2023/0635

Erection of 1 no detached two storey dwelling and associated works including provision of off street parking and rear garden amenity space

22 Filey Avenue, Royston, Barnsley, S71 4PZ

Project	LAND ADJACENT 22 FILEY AVENUE, ROYSTON BARNSELY S71 4PZ	Client	
Drawing Title	FLOOR PLANS AND ELEVATIONS AS PROPOSED	Date	AUGUST 2023
Ref.	104-43	Scale	1:50 @ A2
Dwg. No.	08	Rev.	A

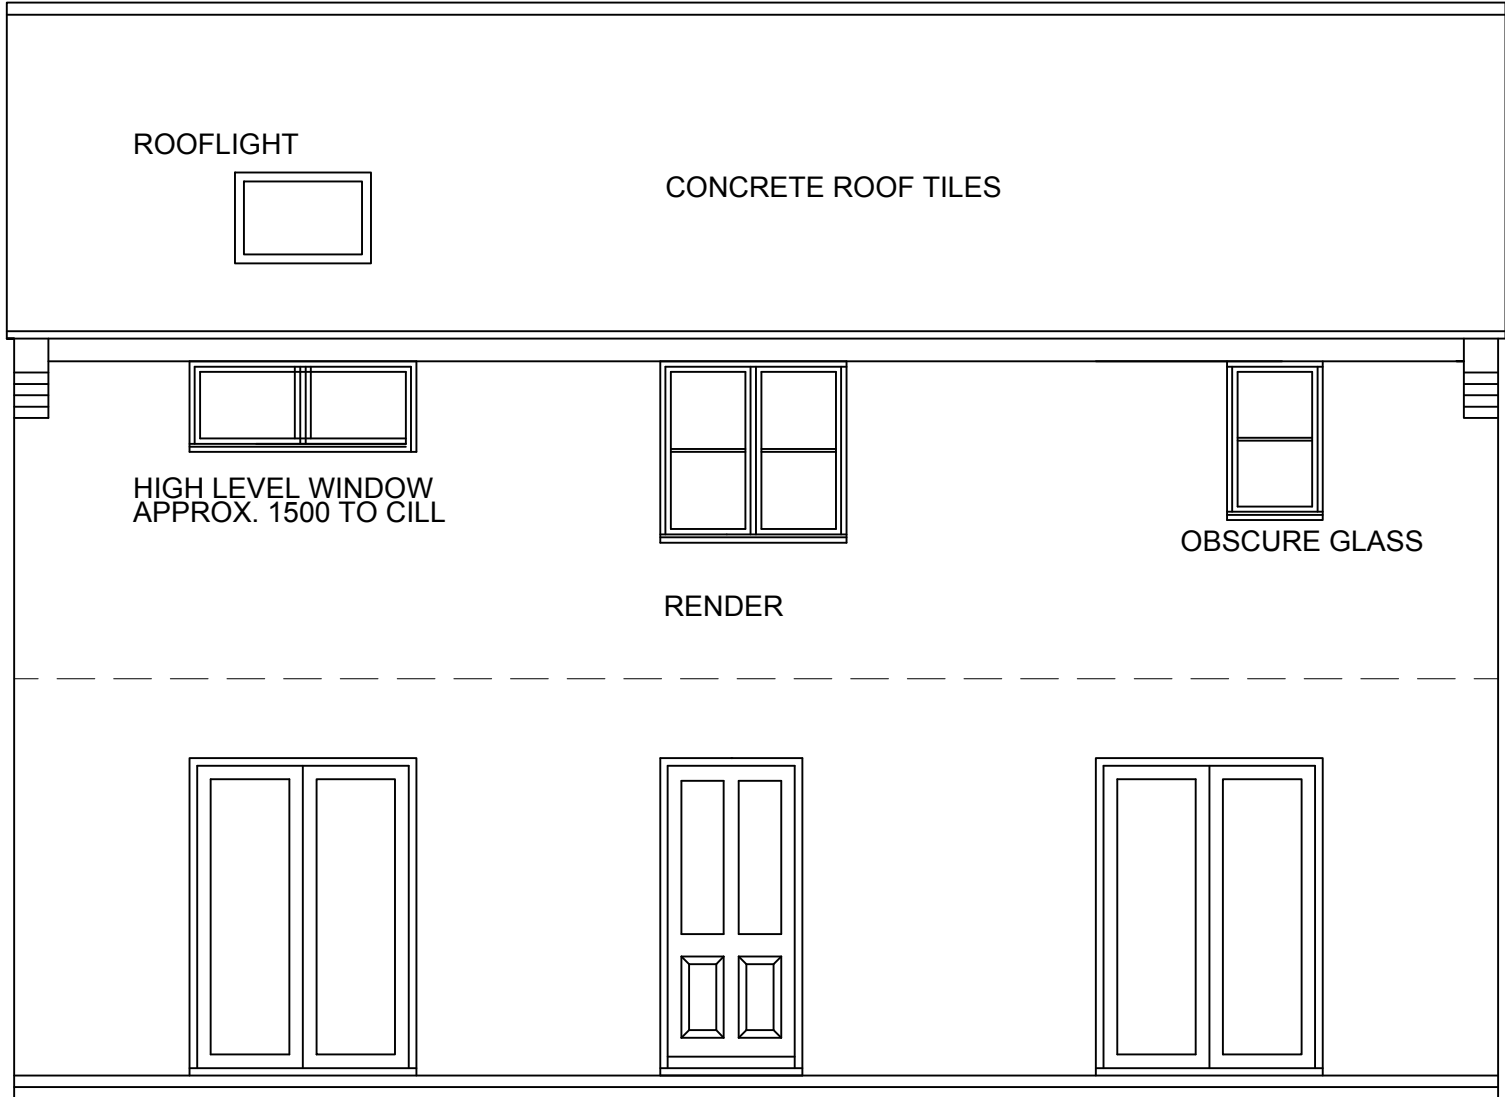
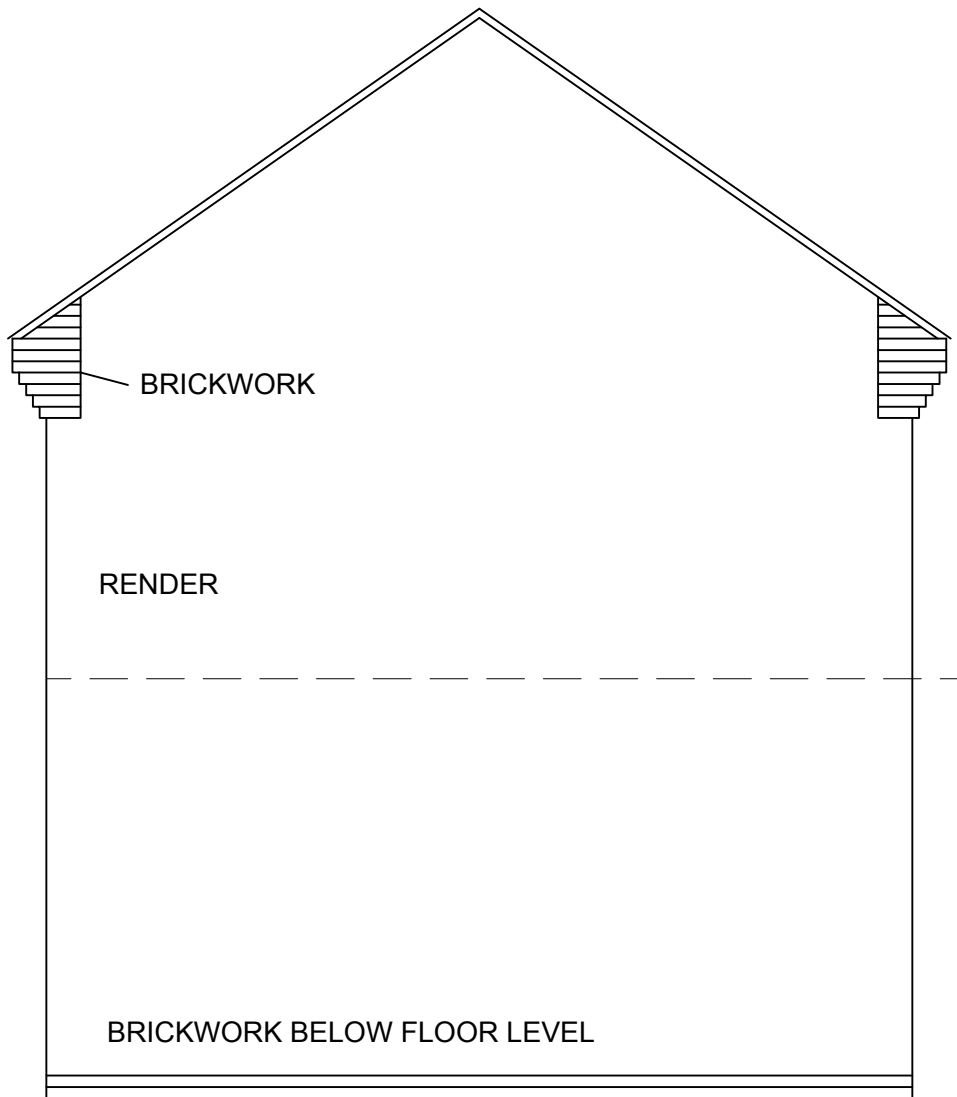
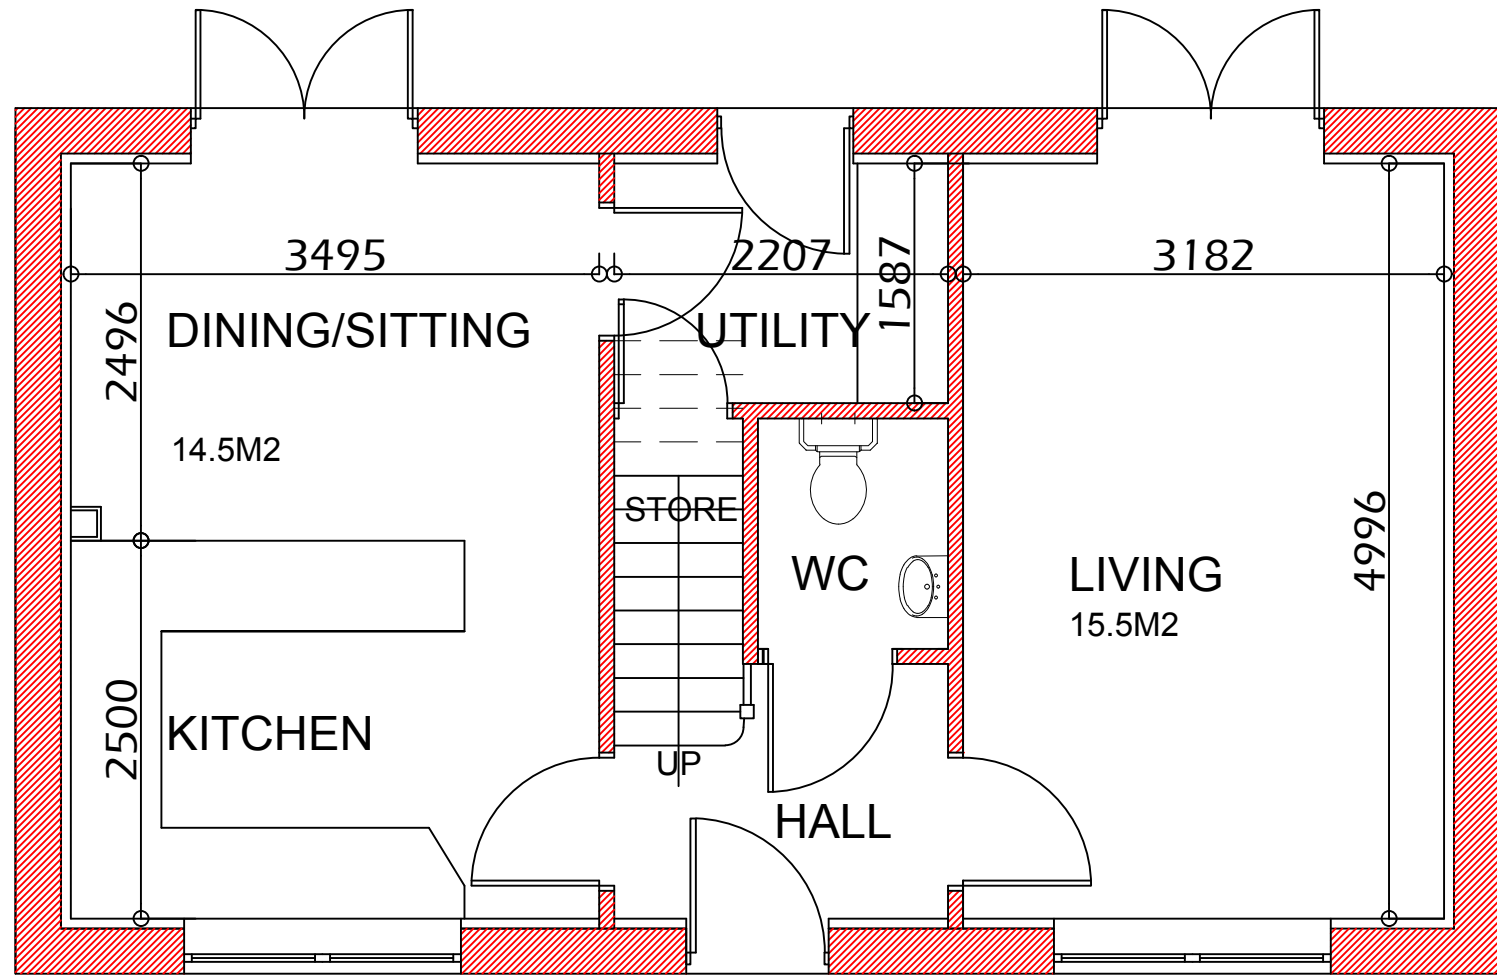
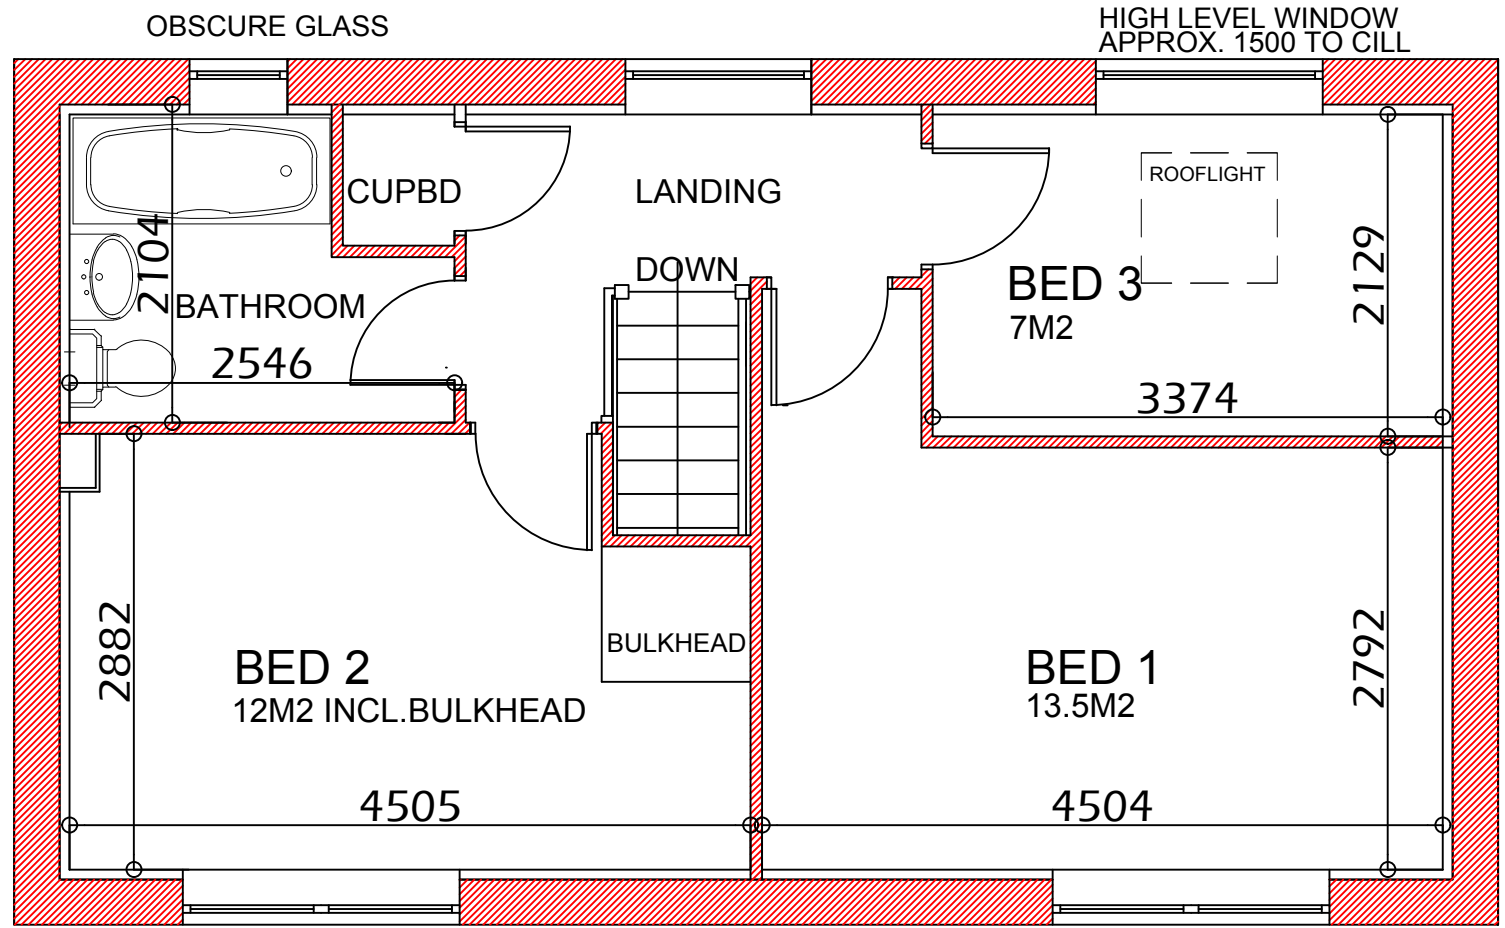
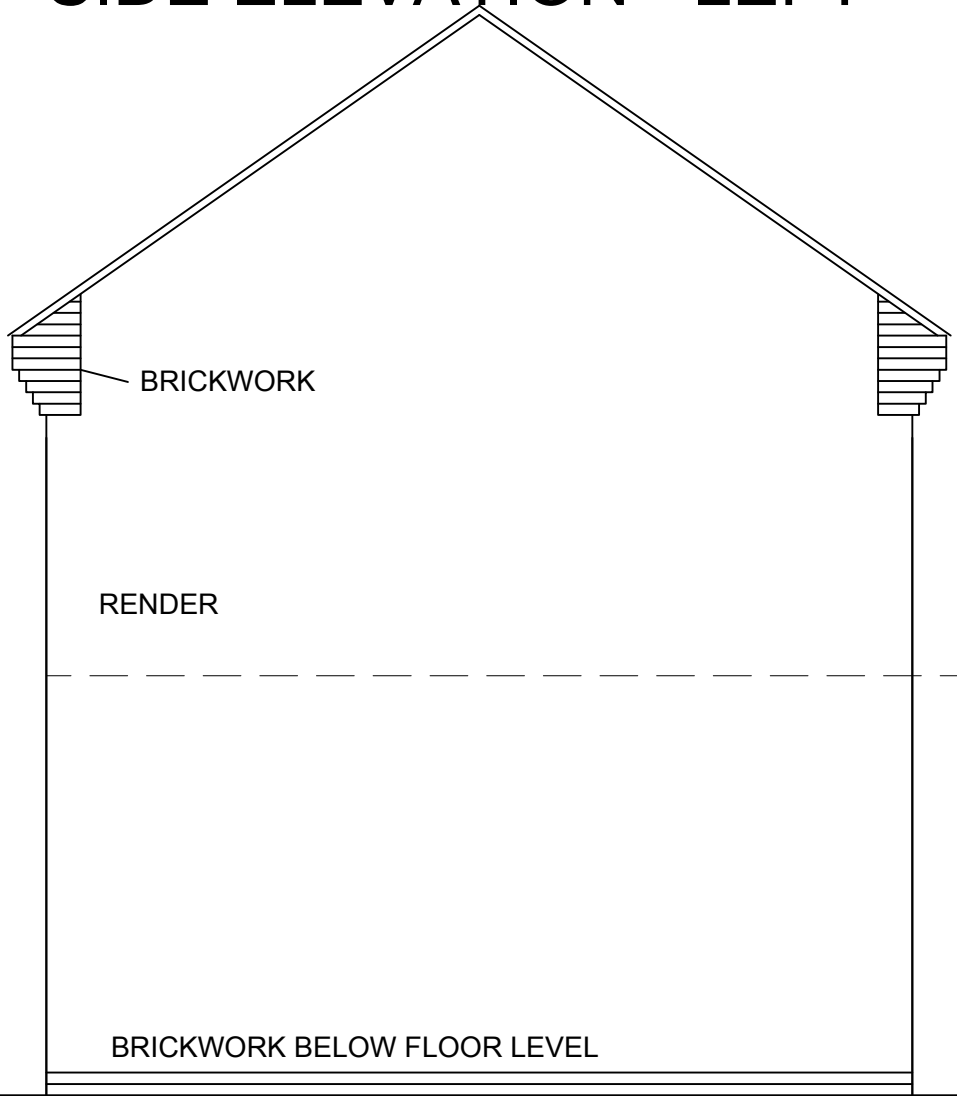
The plot is narrow which results in the rear elevation/windows being at a close distance to the rear boundary line. The proposed development includes 3 x windows on the rear elevation at first floor level, two of which serve non-habitable rooms, with the other serving a bedroom. This initially caused concern as the bedroom window was initially proposed at c.5m from the rear boundary line which is well short of the minimum separation distance expected in the SPD for Design of Housing Development, which expects a minimum of 10m separation distance between habitable room windows and rear boundaries. Alternatives were discussed with the agent, who then submitted an amended scheme showing a high-level window for outlook/light and a rooflight for a means of escape, serving bedroom 3. A cross-section was also submitted showing that the window will be at least 1.5m from ground floor level, reducing overlooking into neighbouring properties to the rear. Whilst this is not fully in accordance with the SPD, the LPA considers that the arrangement will allow for suitable outlook for future residents, whilst significantly reducing the overlooking potential from bedroom 3. The rooflight faces upwards at a high level and too does not cause significant overlooking into neighbouring properties. Further, it should be noted that the existing relationship of dwellings on Filey Avenue is first floor windows on the rear elevation close to rear boundaries, as seen immediately to the North at nos. 22, 24, 26 and 28. Some of these windows are habitable which the agent has confirmed by providing floor plans of nos. 22 and 22, showing habitable room windows on the first floor rear elevation of both properties (both of which are owned by the applicant).

An amended set of plans has been received which adds a note to the elevations indicating that the front will be finished in brick, with the side and rears to be finished in render. Render is firmly a part of the existing palette of external materials in the area however, this is largely limited to the side and rear elevation of residential properties, with the main material being red brick, especially on front elevations. The amended arrangement of brick on the frontage and render elsewhere is considered to be acceptable, subject to additional information confirming the external materials details. This will be secured through a planning condition requiring the developer to submit and agree the details with the LPA, upon commencement.

The applicant is seeking approval for the erection of a detached, two-storey dwelling on land which currently serves as the curtilage area of the host dwelling – no. 22 Filey Avenue – as a garden, parking area alongside hosting a detached domestic garage. The proposed development is considered to be in keeping with the surrounding area in terms of its layout, proportionality to the plot size and general design principles including external materials. The plot size is narrow, with the rear elevation of the dwelling being at a close

distance (5m) to the rear boundary line. This presented concern as the rear elevation contained a habitable room window. An amended plan was presented which replaced the proposed standard window with a high-level window (1.5m high) for outlook and a rooflight for means of escape. This drastically reduces the overlooking potential into the neighbouring properties to the rear to an acceptable level. The proposed development also includes 2 x off-street parking spaces which is in line with the Council's parking SPD as well as being in a sustainable location, in close proximity to the Centre of Royston where growth should be directed and contains a wide variety of local services alongside public transport links, in line with Local Plan Policies T3 and LG2.
